**PAN AMERICAN
ENGINEERS, LLC**

Re: TCL Plan Response
Murphy Express
10601 Unser Boulevard NW
Albuquerque, NM
PAE Job No. 11605

Please see responses to corresponding comments below received by letter dated June 6, 2022 from your office.

SHEET NO. C-3

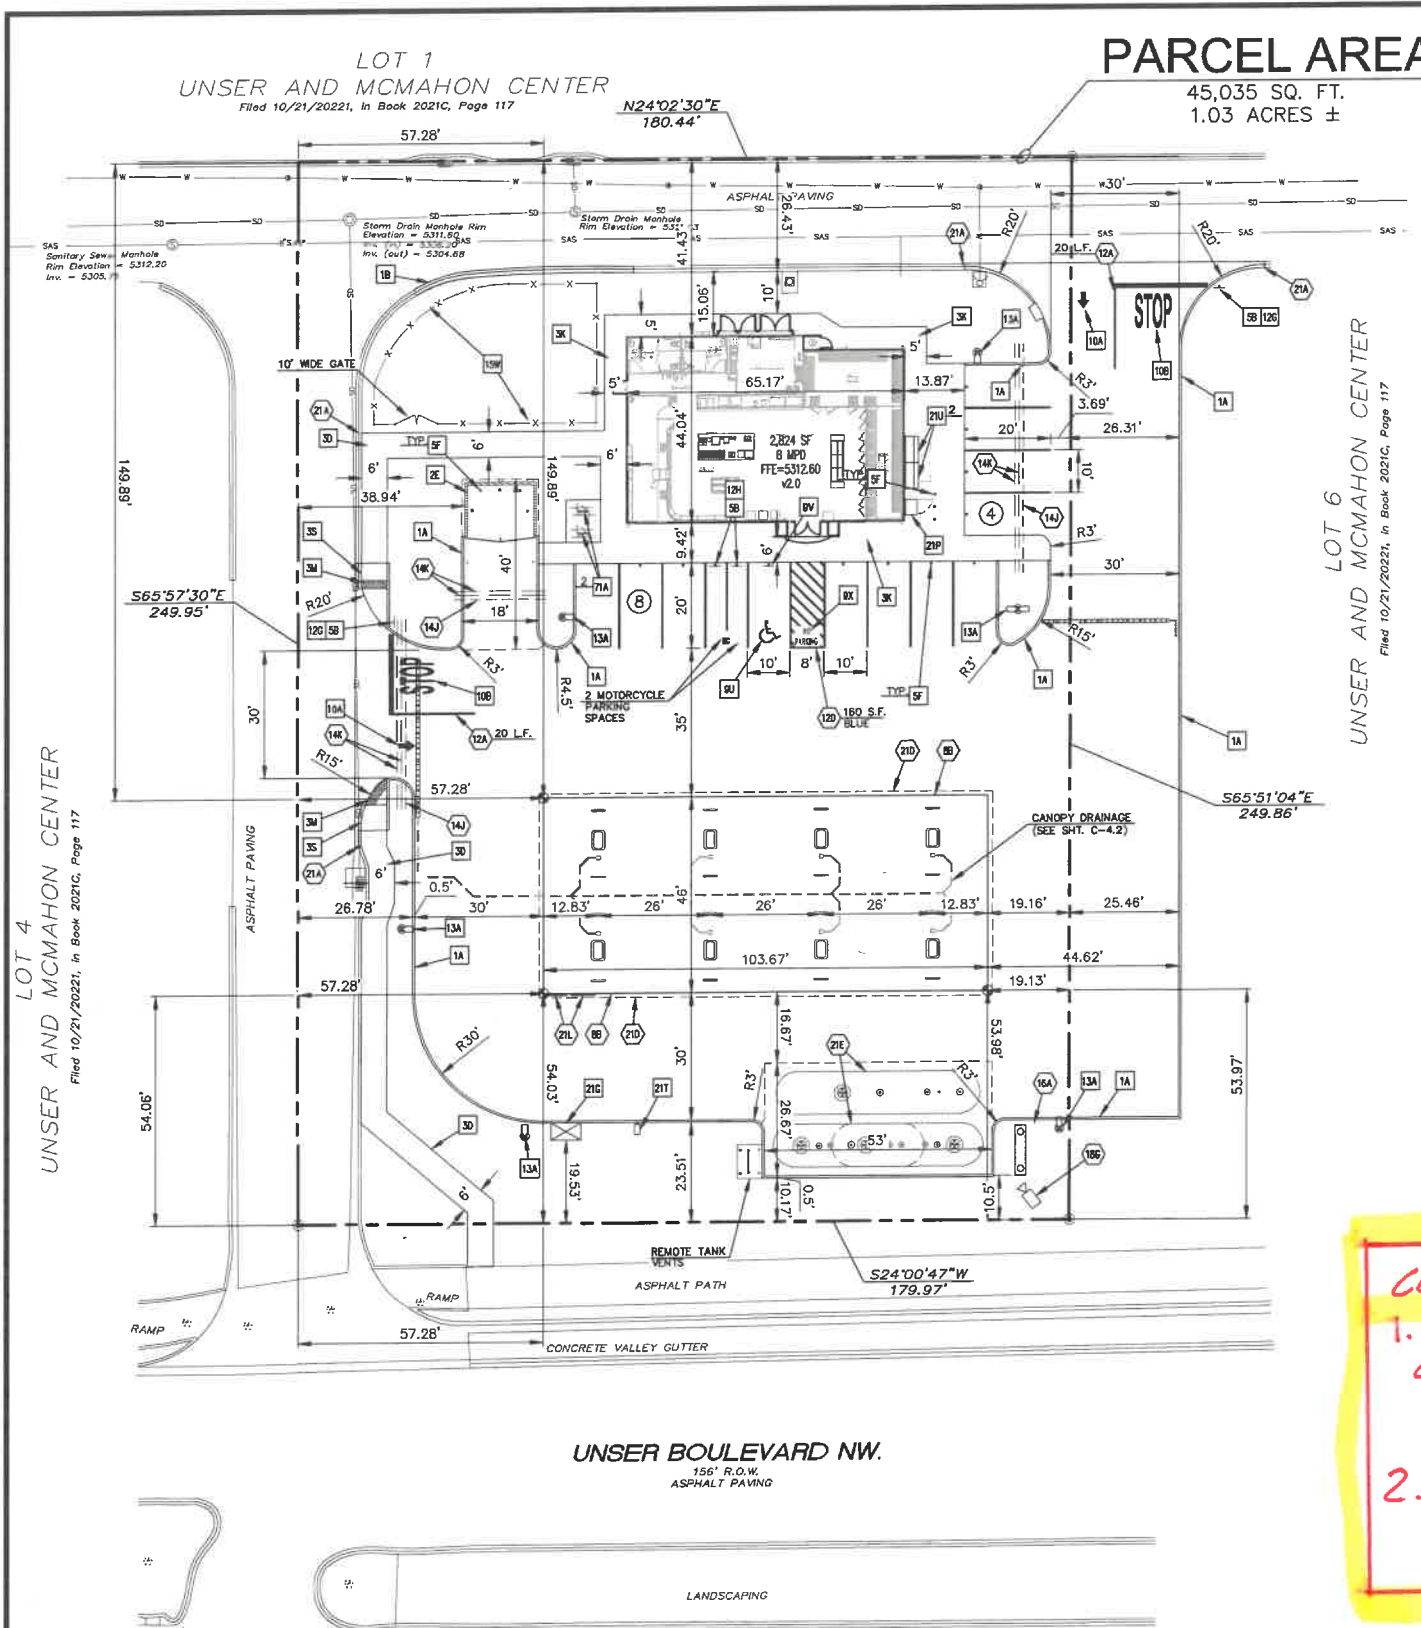
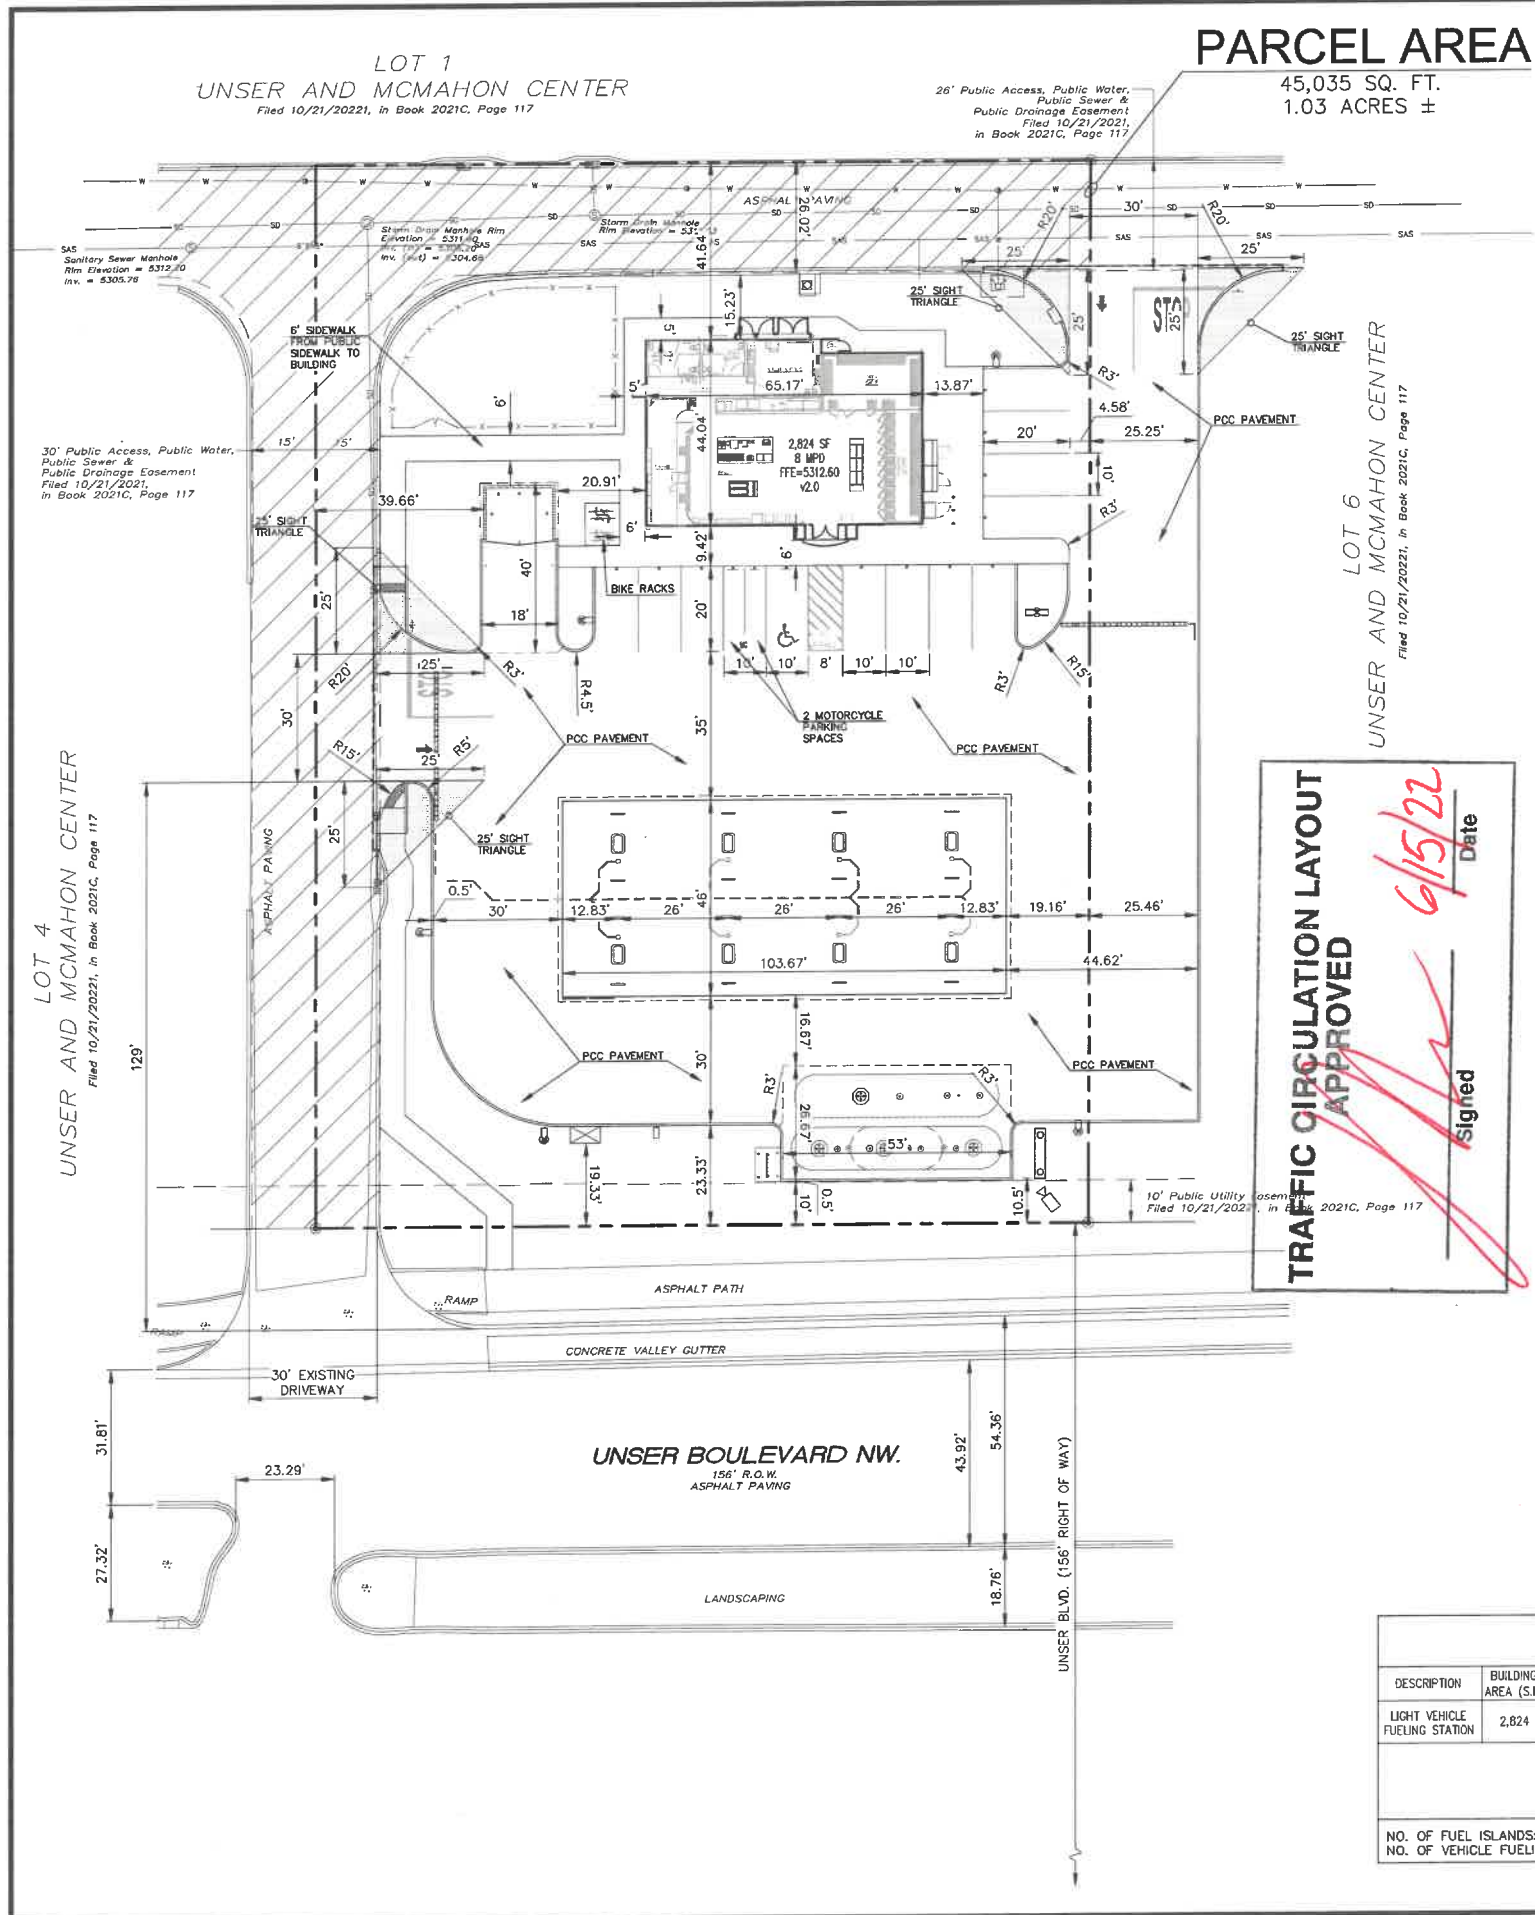
- 2. The proposed 1st entrance drive onto site:*

- a. It is too close to Unser frontage/turn lane and its Main entrance throat length will need to comply with DPM 7.4 (K)(15) throat length.*

- b. The main entrance off Unser is the primary access to all presence and future development design and as such will require a throat depth of 100 ft off the right turn lane.*

- e. *Entrance width is too wide. Please adjust for two-way traffic and delivery vehicle. Provide turning templates.*

Response: This entrance has been deleted. See attached revised plans.

Response: This entrance has been deleted. See attached revised plans. The remaining entrance has a throat length of 129' (Shown on TCL-1, Traffic Circulation Layout); which complies with this requirement.

Response: The remaining drives have been revised to 30 ft. This is the minimum width that will allow for two-way traffic and delivery vehicle access. See attached Sheet C8, Truck Route Plan; which shows turning templates.
(Continued)

SHEET NO.
TCL-2

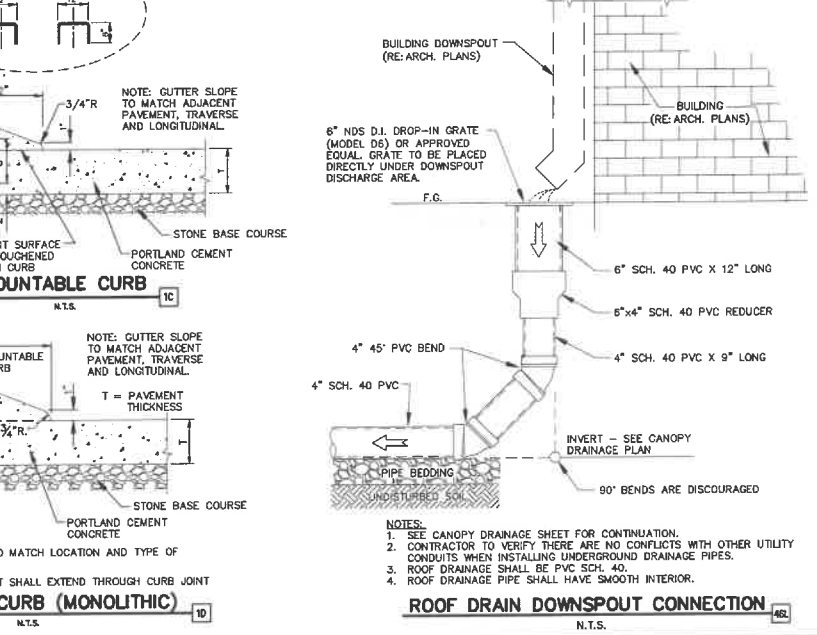
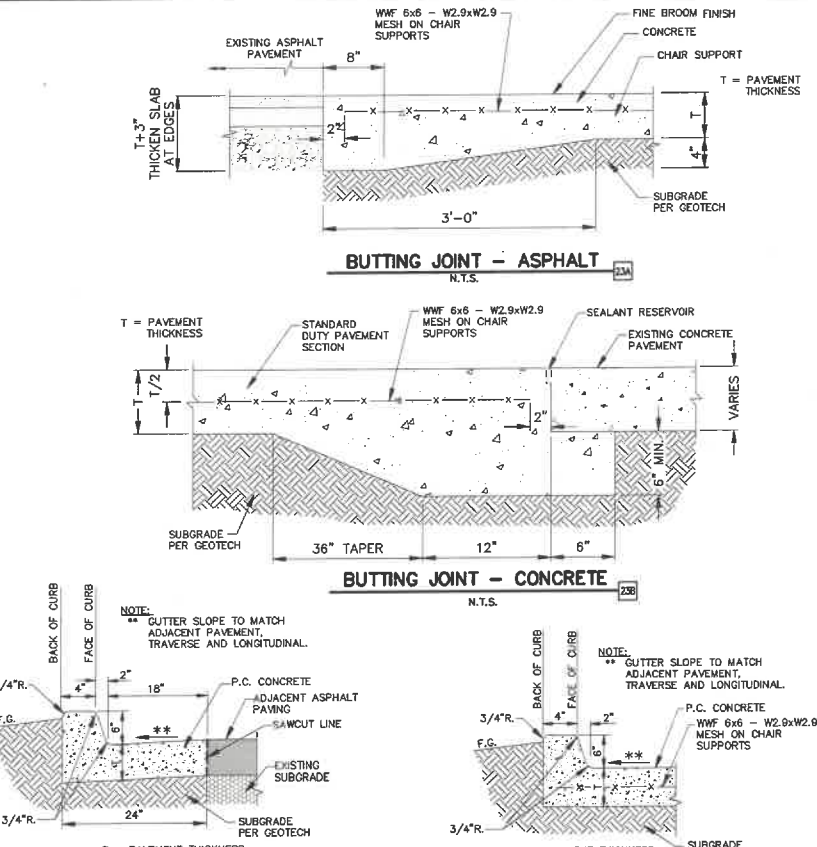
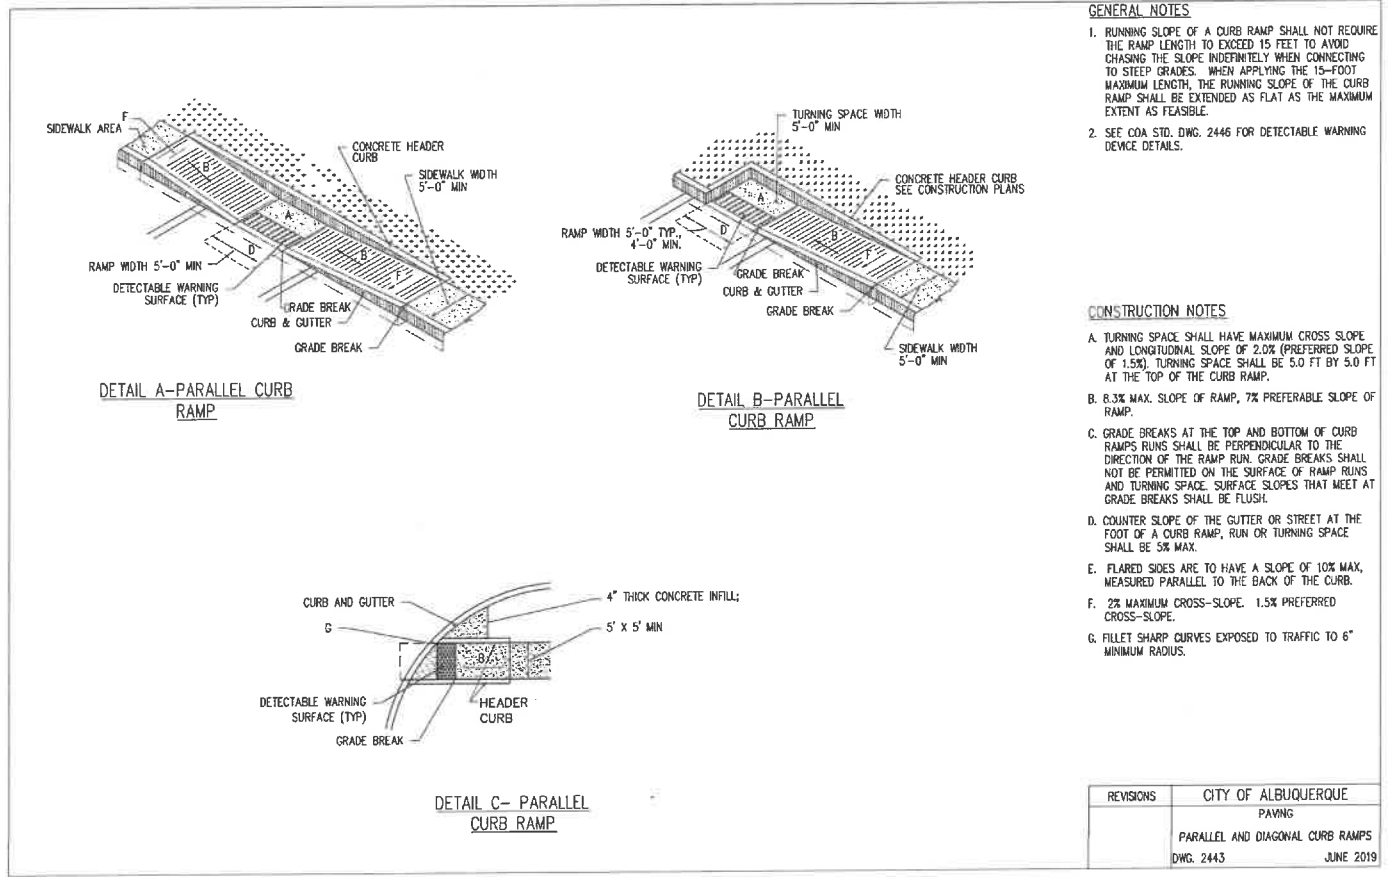
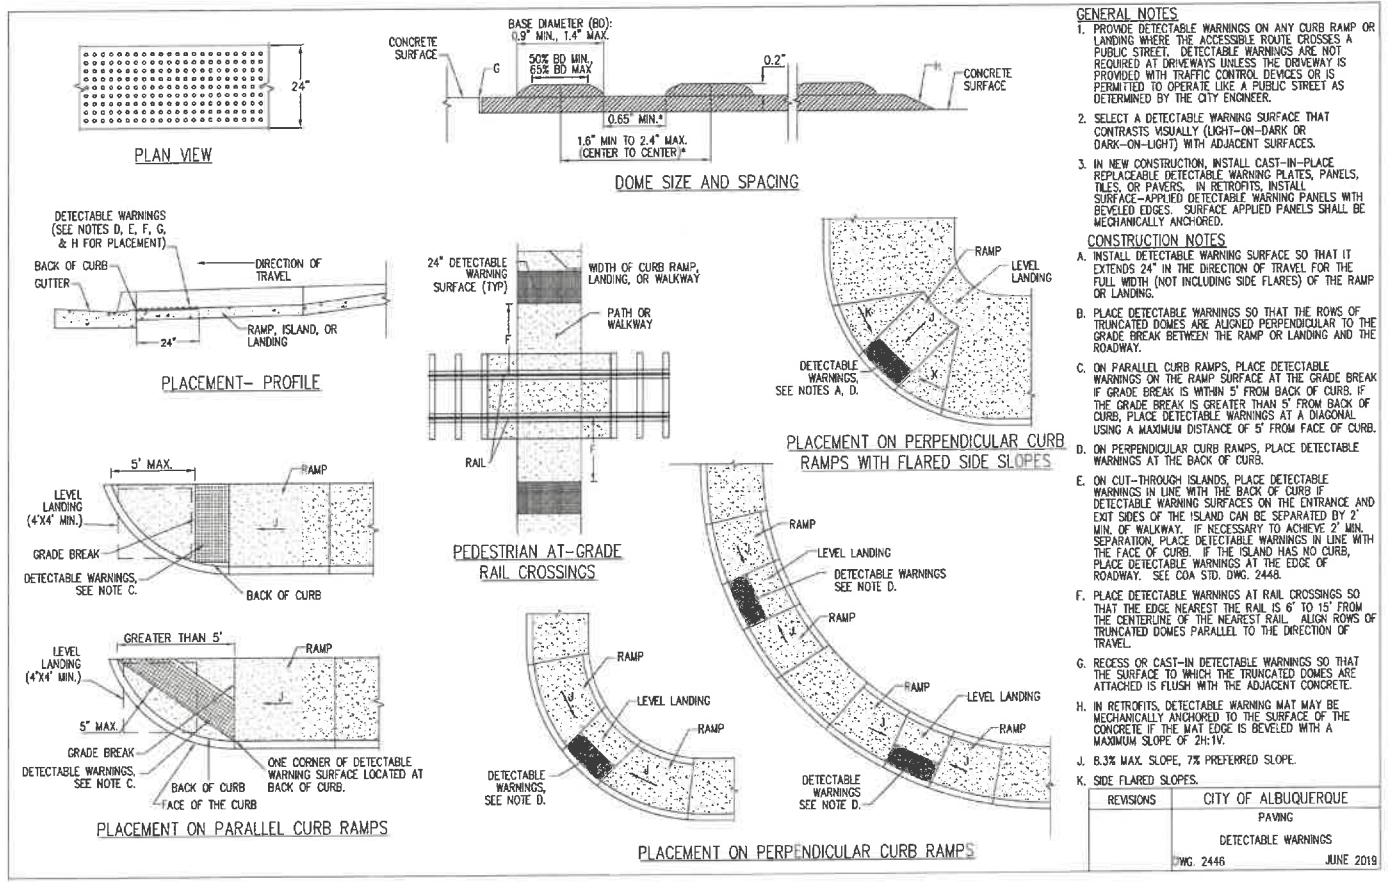
4. *A Intersection Sight Distance off the Unser entrance will need to be provided (Not shown).*

Response: See attached TCL-2, Traffic Circulation Layout showing the requested intersection sight distance which shows no obstructions within the intersection sight distance.
